Outer Dowsing Offshore Wind (Generating Station) – EN010130

Section 51 advice regarding draft application documents submitted by Total Energies and Corio Generation

On 13 October 2023 Outer Dowsing Offshore Wind submitted the following draft documents for review by the Planning Inspectorate as part of its Pre-application Service¹:

Drawing No: PP1-ODOW-DEV-CS-MAP-0002

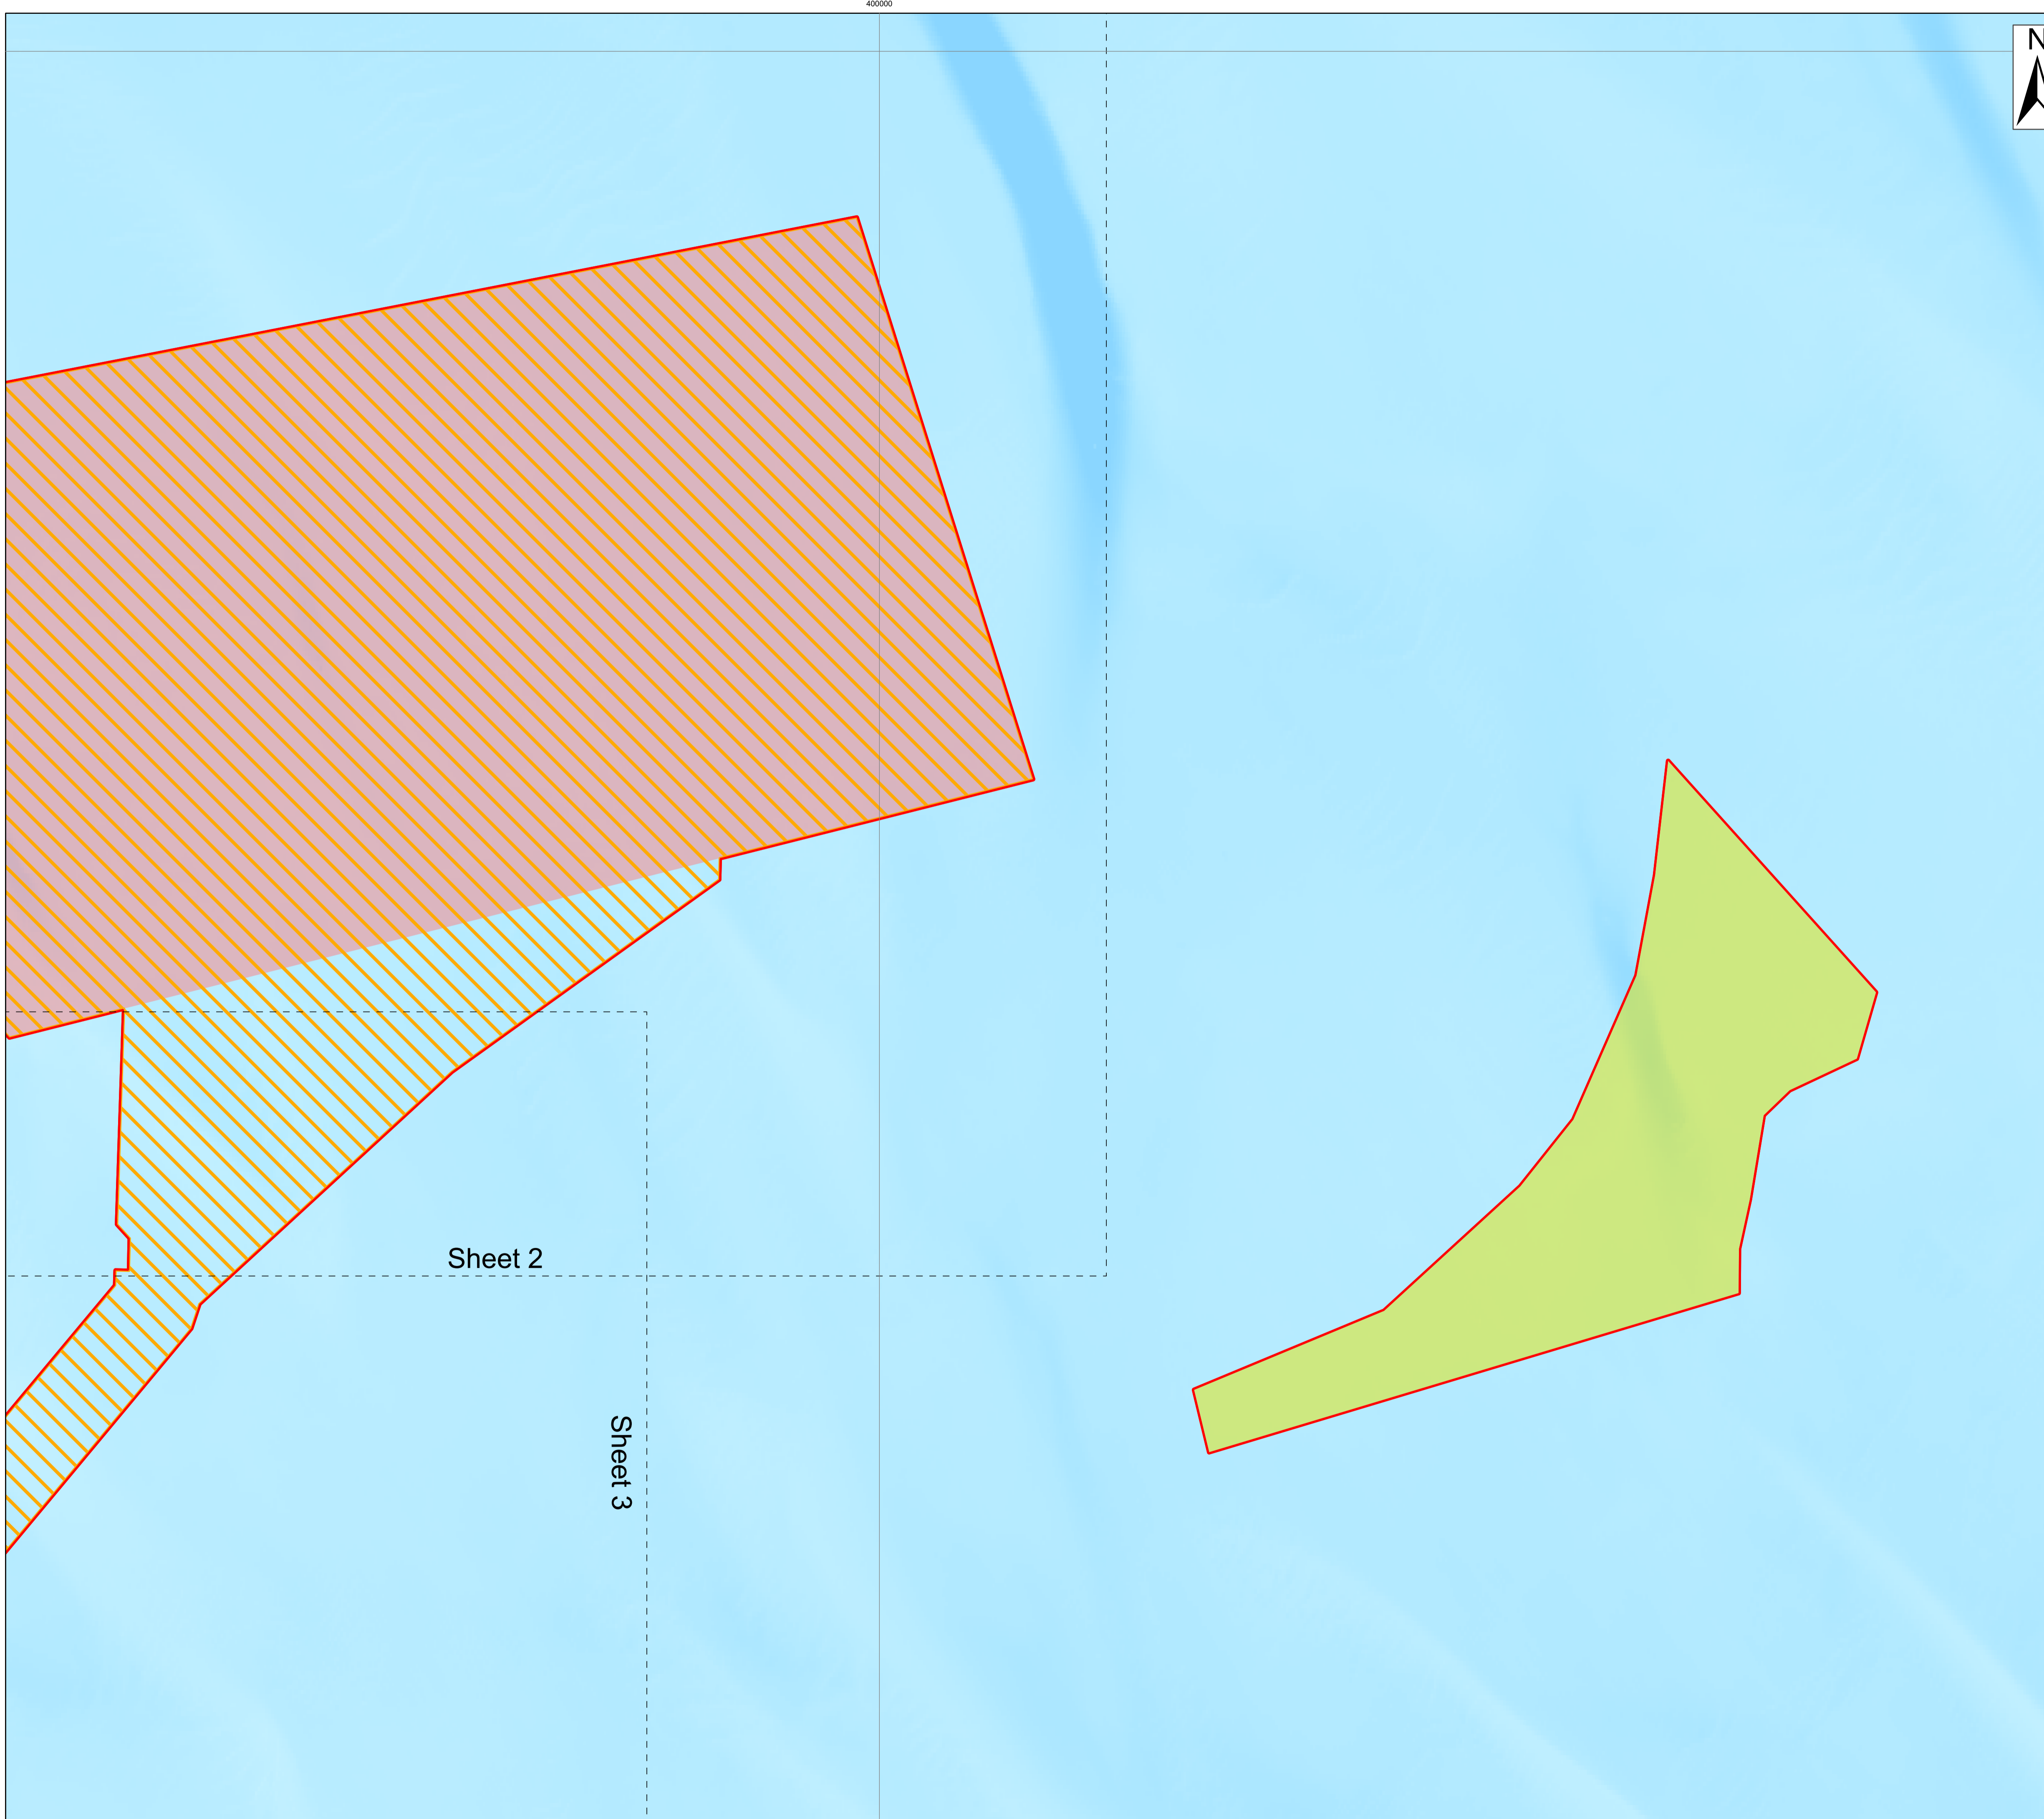
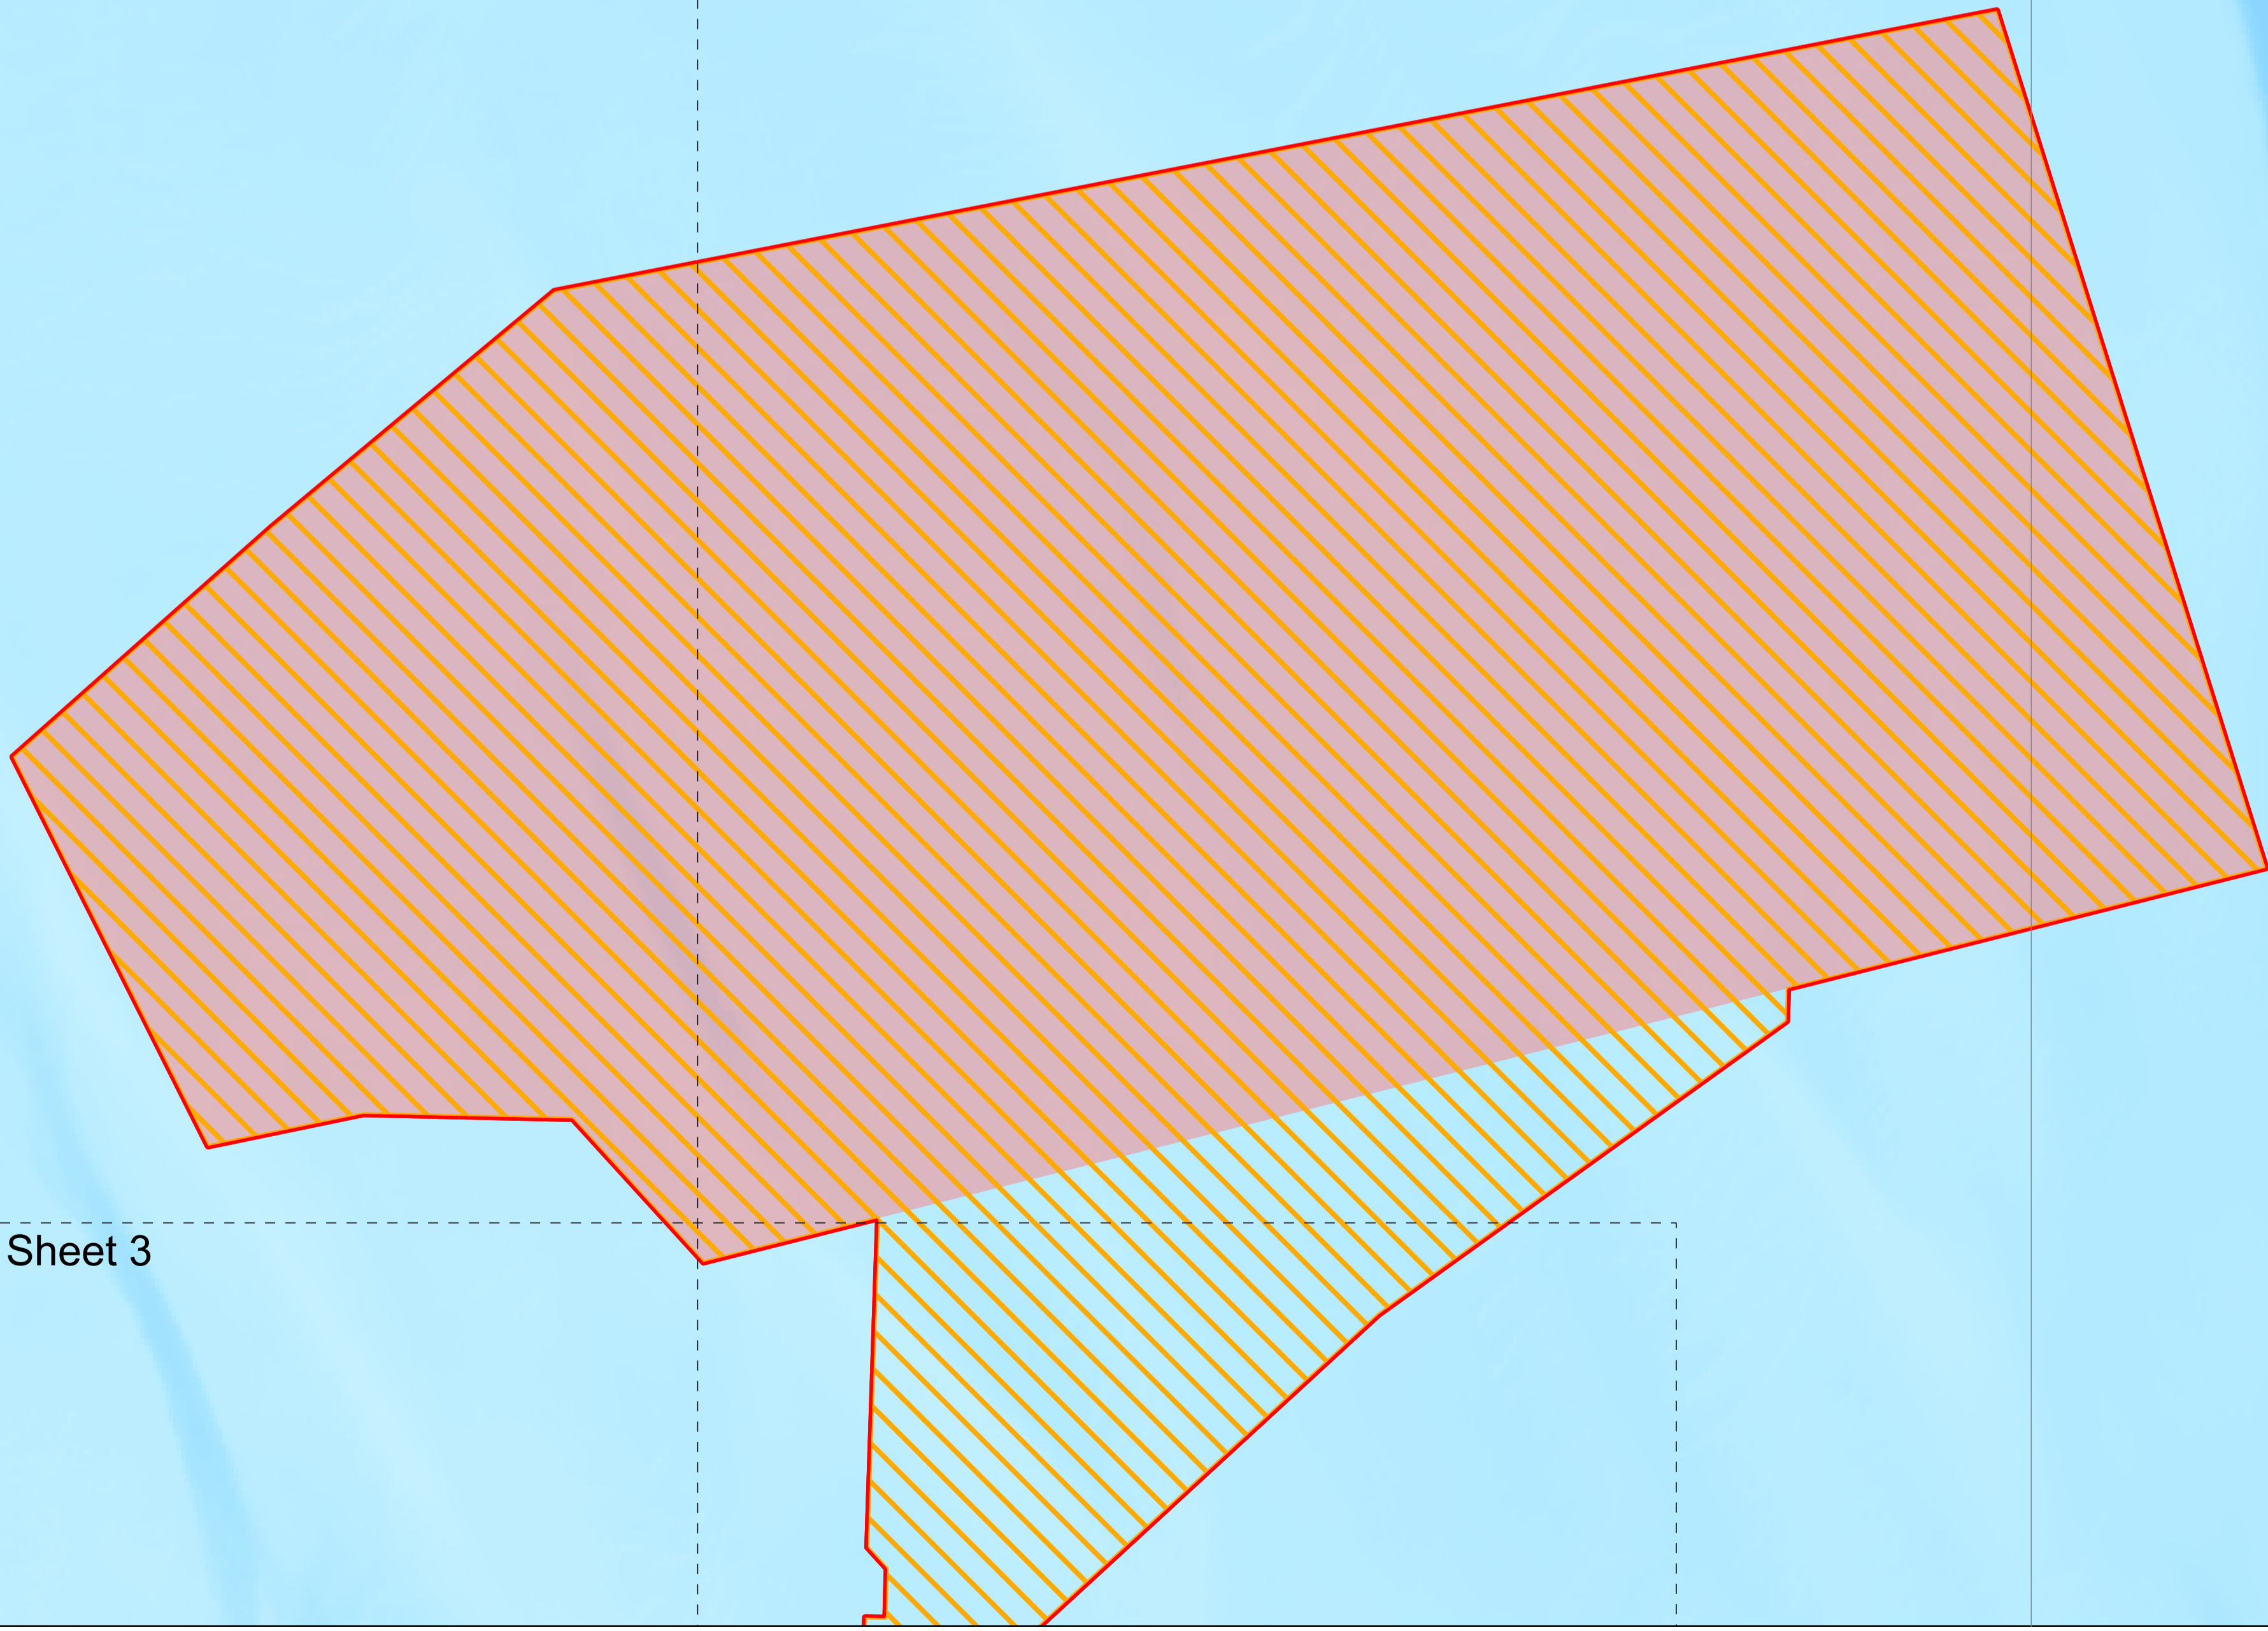
Offshore Works Plans		
Ref No.	Plan ref	Comment/Question
30.	All	Works No. 5 – Offshore export cables and Works No. 8 – Temporary works areas have the same legend colour and pattern. If there are any temporary work areas that include any works other than export cables then they should have a different colour and/or pattern.
31.	Drawing 1 of 5 Drawing 3 of 5	Works No. 10 – Creation and recreation of biogenic reef – This is not included in the Order limit boundary. Is this intentional or an oversight? If intentional, what is the justification for its exclusion?
